Description: Restoration of windmill and use of granary to provide museum/display/educational facilities and tea room

Location: Moulton Windmill
High Street
Moulton
Spalding Lincs

Amendment: Modern brick wall to be demolished
(Dwg. no. 49.11.A)

**TOWN AND COUNTRY PLANNING ACT 1990
NOTICE OF ACCEPTANCE OF AMENDMENT**

FIRST FLOOR

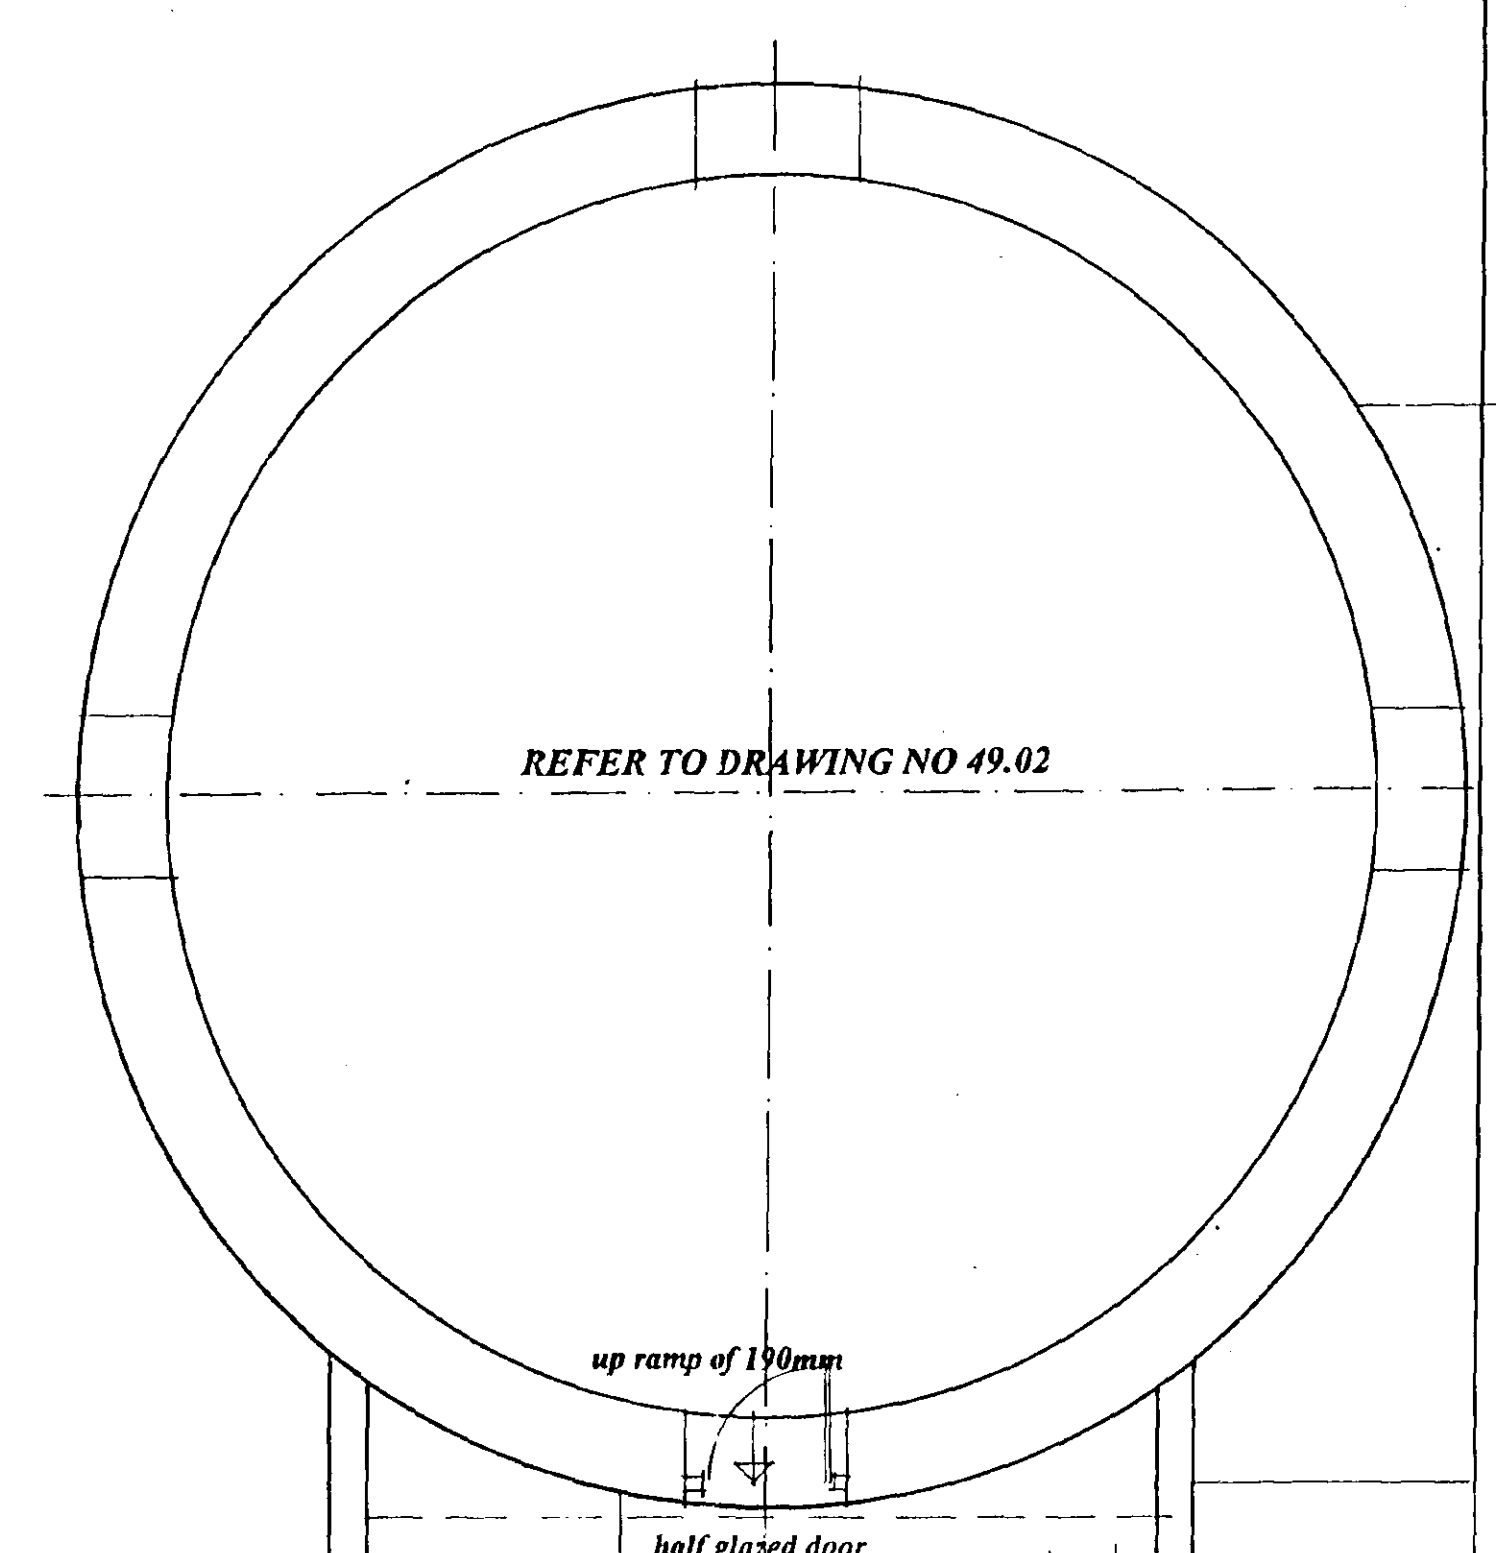
MODERN BRICK WALL TO BE DEMOLISHED - AS AGREED WITH JOHN BIGGADIKE
